From: [REDACTED]
To: [Metrowest1](#)
Subject: Deadline 6 Submission - Issue Specific Hearing 5, Dealing With Environmental Matters, 4th March 2021 - Comment Regarding Action 31
Date: 14 March 2021 21:44:14

Application by North Somerset District Council for an Order granting Development Consent for the Portishead branch line – MetroWest Phase 1

Issue Specific Hearing 5, Dealing With Environmental Matters, 4th March 2021

Action No. 31 for Applicant:

Drawn
COMPOUNDS, HAUL ROADS AND ACCESS TO WORKS PLAN SHEET 5

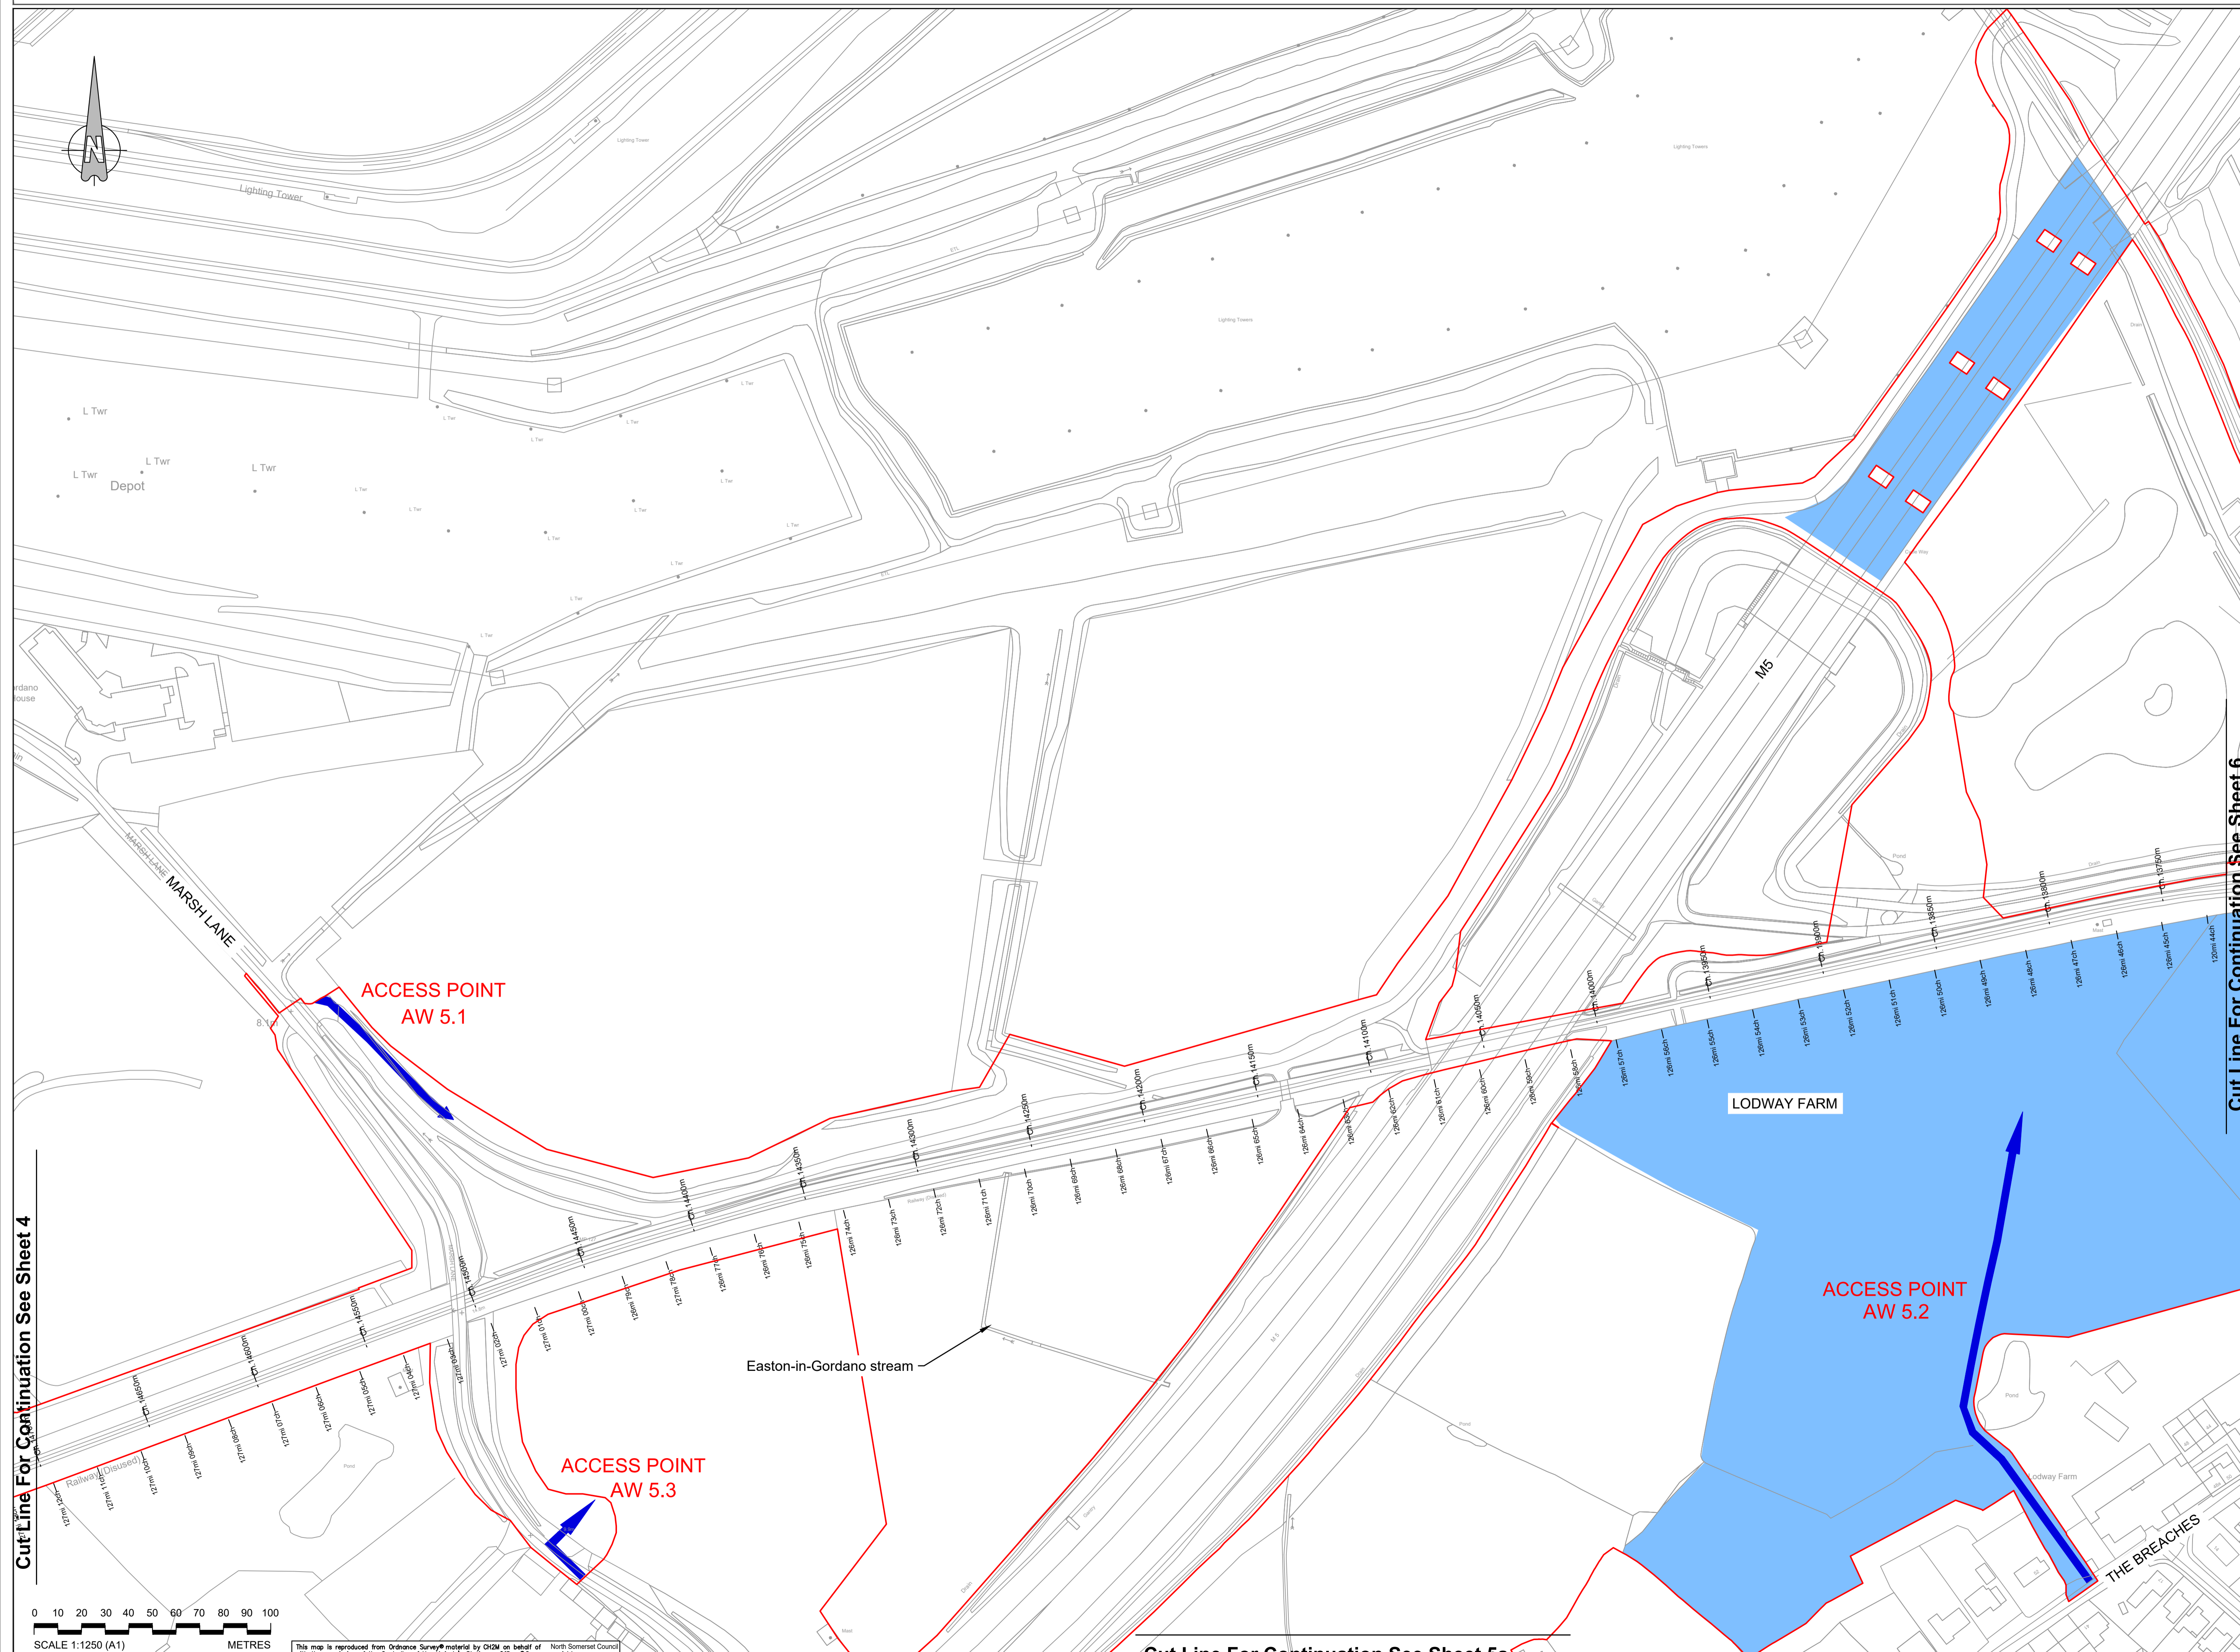
3. I became aware during the course of the Hearing of a new factor potentially affecting the haul road when it emerged that the direction of laying of the new track laying would now be to the west commencing from the Pill end. On the DCO 2.4 General Arrangement Plan the haul road is shown as running through the M5 overbridge in the same space as the railway line. Given the narrow width through the overbridge, it seems very unlikely that there is room for the haul road to run side-by-side with the railway, especially when the new line is being laid through the over bridge. Thus, there is a severe risk that once laying of the new line commences it would be only a short time before the haul road access to the Lodway Farm Compound would become unviable. In that case, the only other access identified for Lodway Farm would be via The Breaches. This takes us back to the heart of our concerns about continuous availability of the haul road. Therefore, I request that the Applicant also address this issue when responding to Action 31.

THE PORTISHEAD BRANCH LINE (METROWEST PHASE 1) ORDER
COMPOUNDS, HAUL ROADS AND ACCESS TO WORKS PLAN SHEET 6 PILL

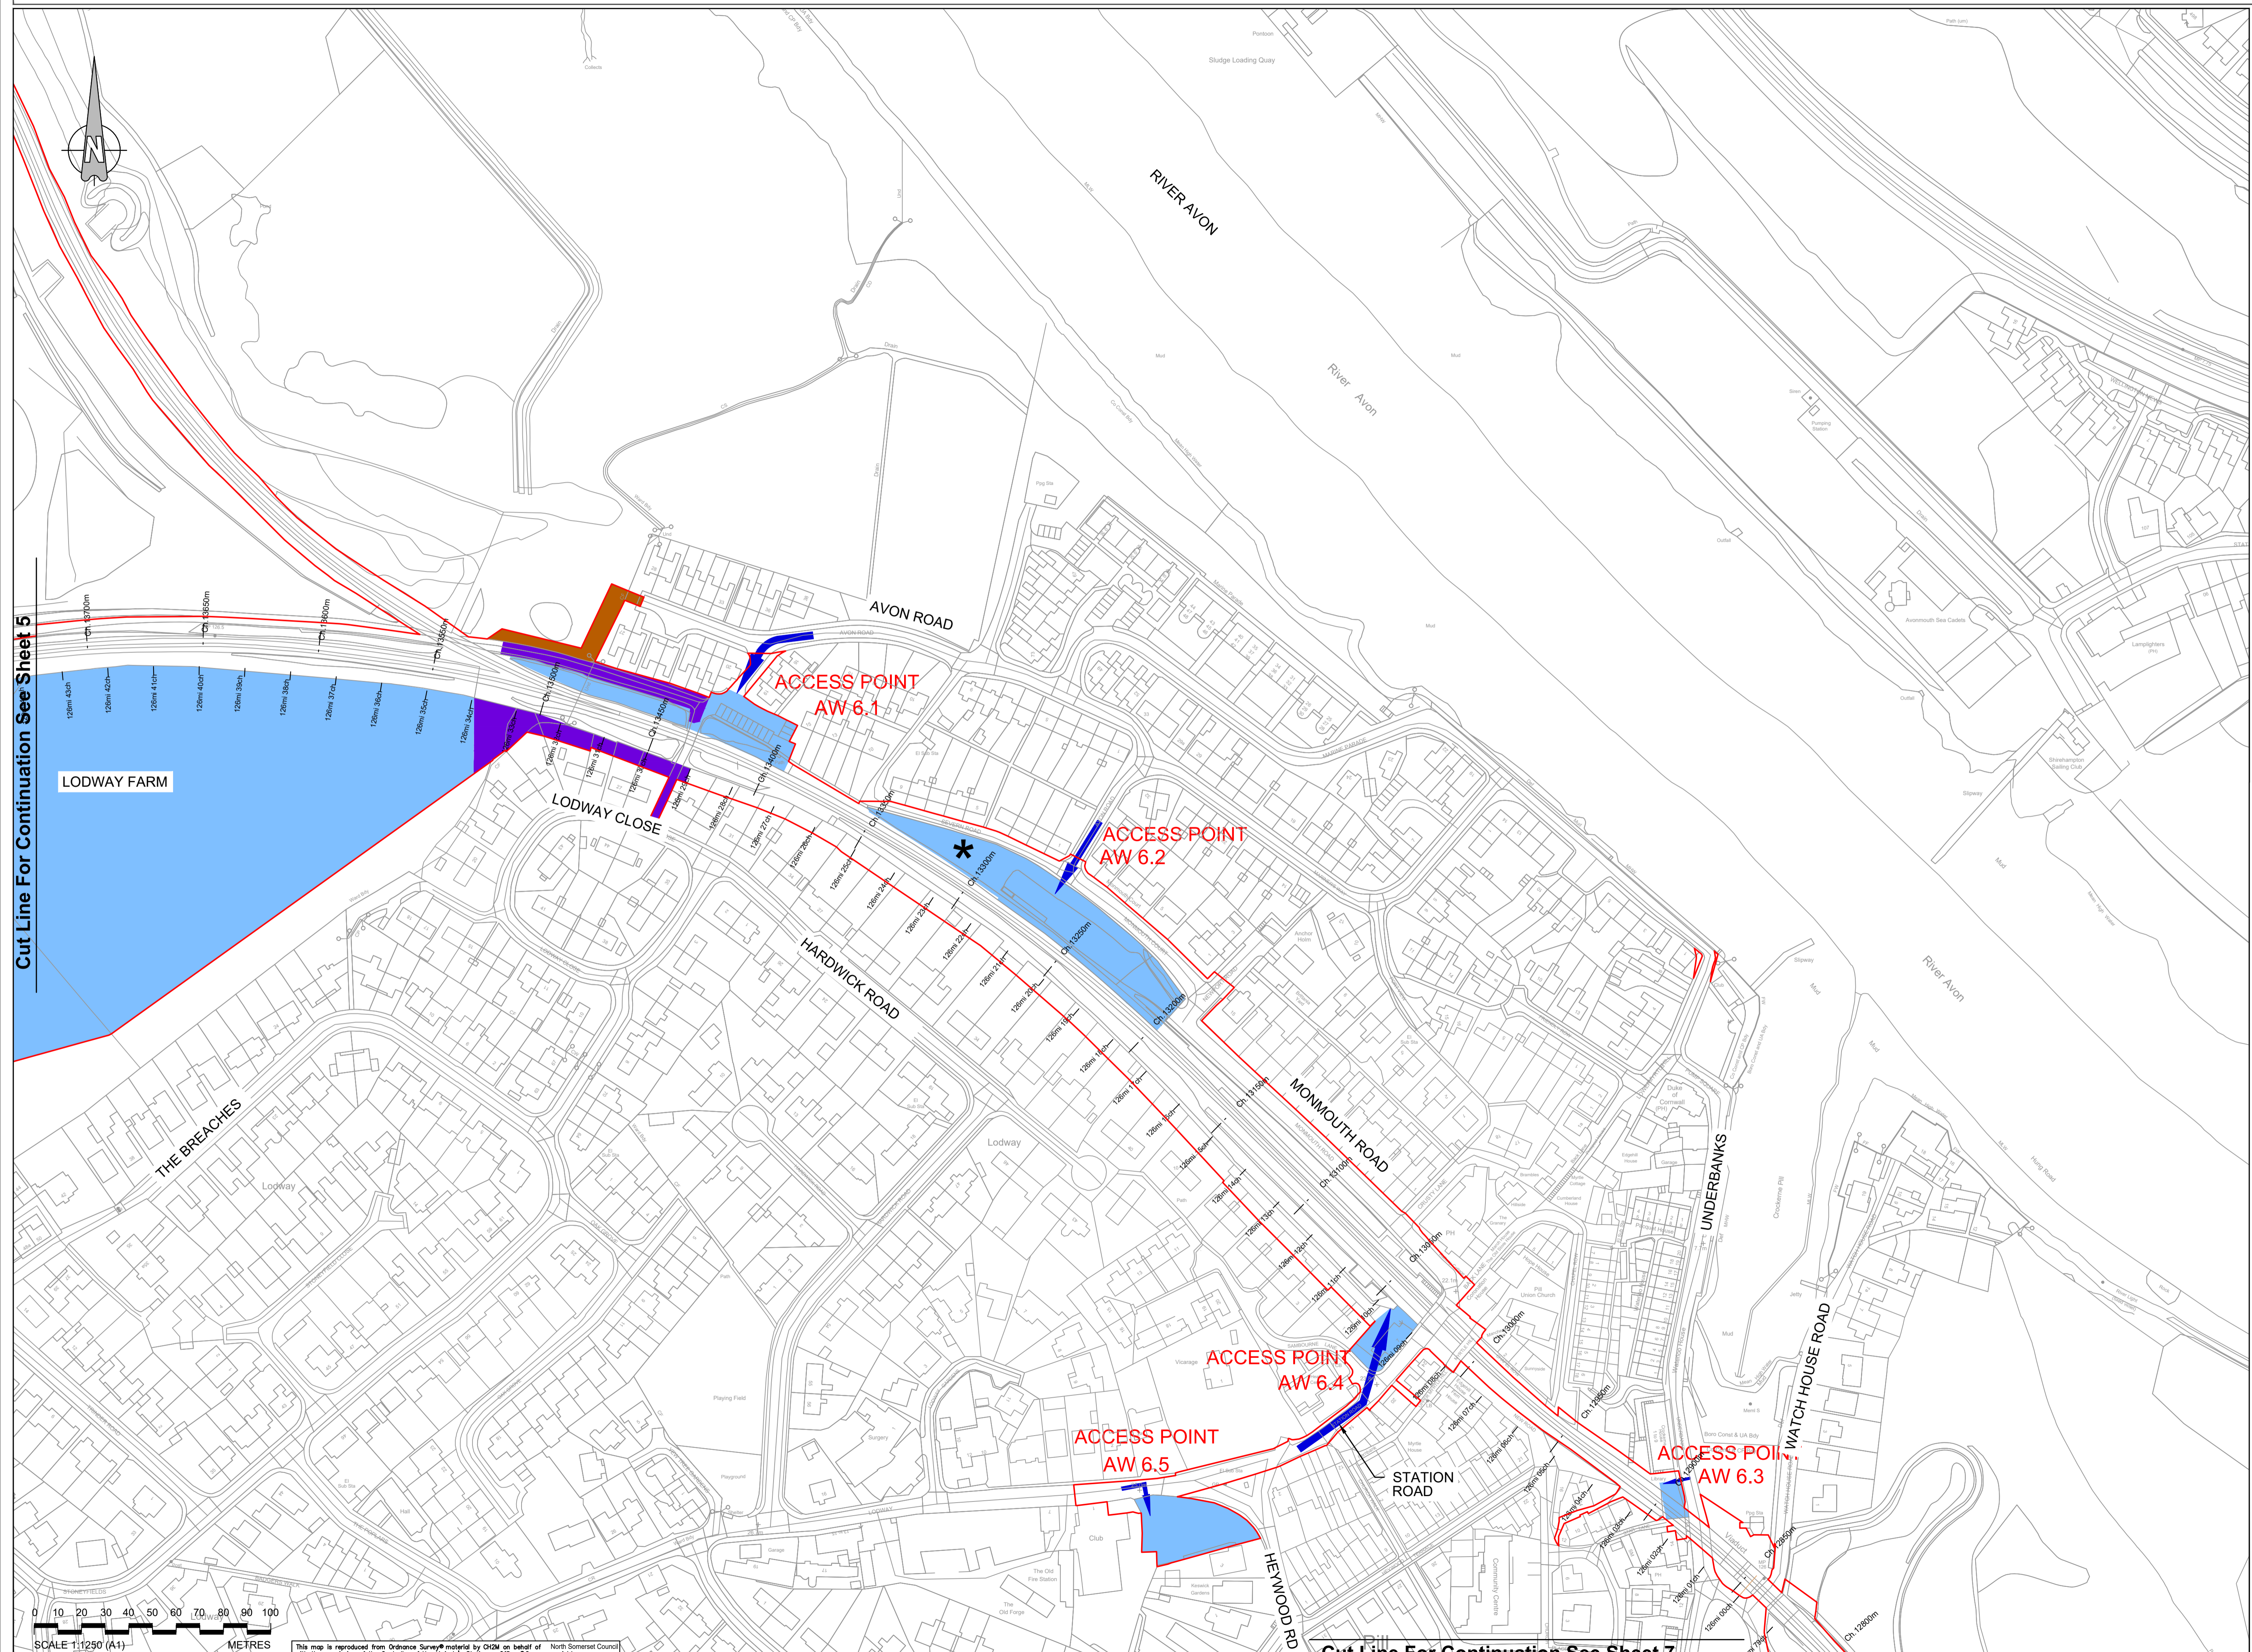
1. Action 31 makes no mention of the concerns that Mr Berry and I expressed at the hearing regarding the unsuitability of the Pill and Easton-in-Gordano road system for construction HGV traffic. On the routes identified in the DCO for Metro West construction traffic we have particular concerns with regard to Lodway and The Breaches, especially for movements to/from the Lodway Farm Compound, due to the narrow and winding villages roads. We strongly disagree with Mr Willcock's assessment, expressed during the hearing, that these roads are suitable for construction HGV traffic. We raised the questions about the haul road and the railway siding mentioned in Action 31 because of these concerns. It is fundamental to the safety and well being of the village residents who use these roads that the overwhelming majority of the HGV traffic using the Lodway Farm Compound be channelled along the haul road alongside the disused railway. For this to be the uninterrupted case throughout the construction phase, the haul road must be made fit for purpose from the outset. This will require:

a. The load-bearing surface to be strong enough and durable enough to sustain intensive movements of heavily laden vehicles for a period of up to two years. If the haul road had to be closed for repairs for more than a day or two during the construction phase this would inevitably place huge pressure on the contractors to divert HGV traffic to The Breaches access to Lodway Farm.

b. The haul road to be widened wherever possible to enable two HGVs to pass one another. It is our contention that this is essential in order to make the haul road route viable for multiple inbound and outbound journeys to/from the Lodway Farm Compound. Otherwise, it can be envisioned that a one-way system might be instituted using The Breaches to ingress Lodway Farm and the haul road for outbound traffic in order to maintain traffic flow through the compound. This should be specifically ruled out in the DCO, as it would place an unacceptable burden on the surrounding roads. Mr Willcock stated that water features adjacent to the haul road preclude this. There are, indeed, short sections of the haul road where that might be the case but from personal observation I believe that there is space for the great majority of the road to be widened to two-lane width to enable vehicles to pass safely.

2. With regard to my comments at the Hearing about the possible railway siding into the Lodway Farm Compound mentioned in the DCO, it is clear that a viable haul road capable of sustaining two-way traffic will be required anyway. Provided that MetroWest project HGV's are kept away from the village road structure, it is not of direct concern to us whether the materials are transported to/from the Lodway Farm Compound via the haul road or by rail. Intuitively, it seems that a dedicated railway siding would be the better option for the local environment. However, it was clear from the comments made by Mr Willcock and, I think, Mr Willmot that, for a variety of reasons, this would not be a practicable solution. The appearance of the railway siding option in the DCO is therefore something of a red herring. This again, reinforces the necessity of ensuring that the haul road is improved to make it fit for purpose from the outset.
